Discharge of Planning Condition (10) (Ref Y/9/15/DOC)

Registered: 21-JAN-15
Site Address: Land Associated with Rookery Farm North of
A259 Flansham PO22 8NN

condition imposed under Y/14/14/ relating to conditions 3, 7, 10, 11, 12 & 14 for full details of external materials, inverter stations, transformers, substation, CCTV & securing fencing, precise height of solar panels, landscaping scheme, archaeological recording & monitoring, temporary arrangements for access for construction traffic & Construction Management Plan.

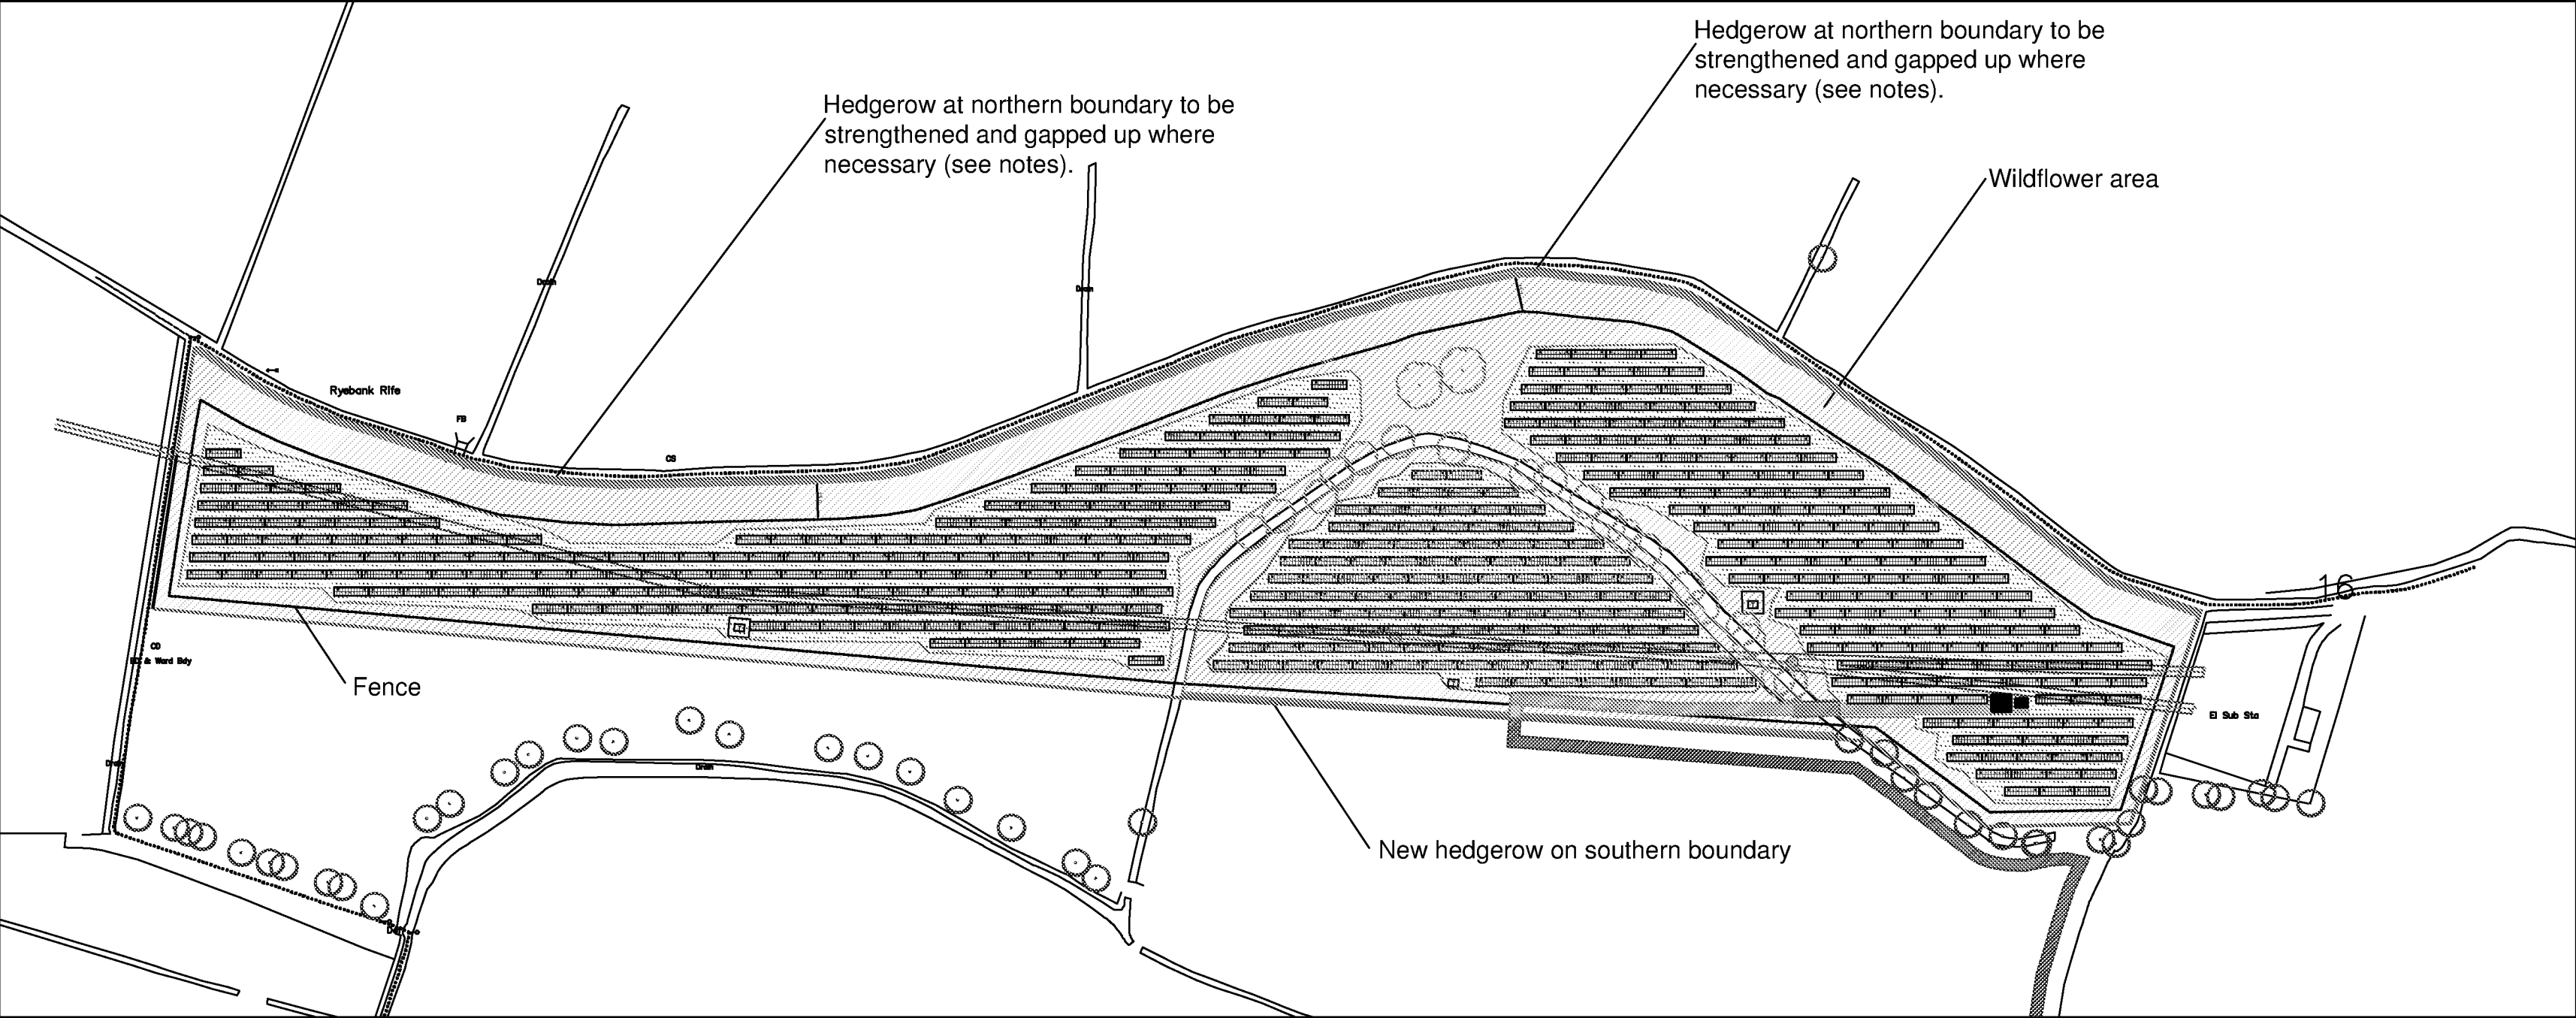
Landscape drawing LE12330-001 details areas to be planted and areas to be infilled along with an indicative species mix which does indicate size at time of planting and densities. **However** this plan is only indicative and needs to show this information plotted on the drawing with actual planting quantities rather than just the stated percentage composition.

We would not be able to recommend the discharge of Condition 10 on this application until the above information has been supplied for approval.

I have viewed the planting proposals which are now set out to confirm numbers of plants that will be incorporated into the scheme both for the new and gapped up hedgerow areas.

From the information submitted I would be happy to recommend the discharge of Condition 10 on this application, please re-submit your drawing through the normal planning portal, where I will be able to formally respond my recommendation.

As per our conversation yesterday we have now added plant numbers to the planting plan (attached). As discussed we have made a best estimate for the 'gapping up' planting to the northern hedge based on photography and mitigation proposals within the LVIA and a review of aerial views on Google Earth. In reality I think the 15% figure for gapping up will provide an over estimation of numbers required, however, this can be ground-proofed at the time of letting the landscape contract and plant numbers adjusted accordingly.
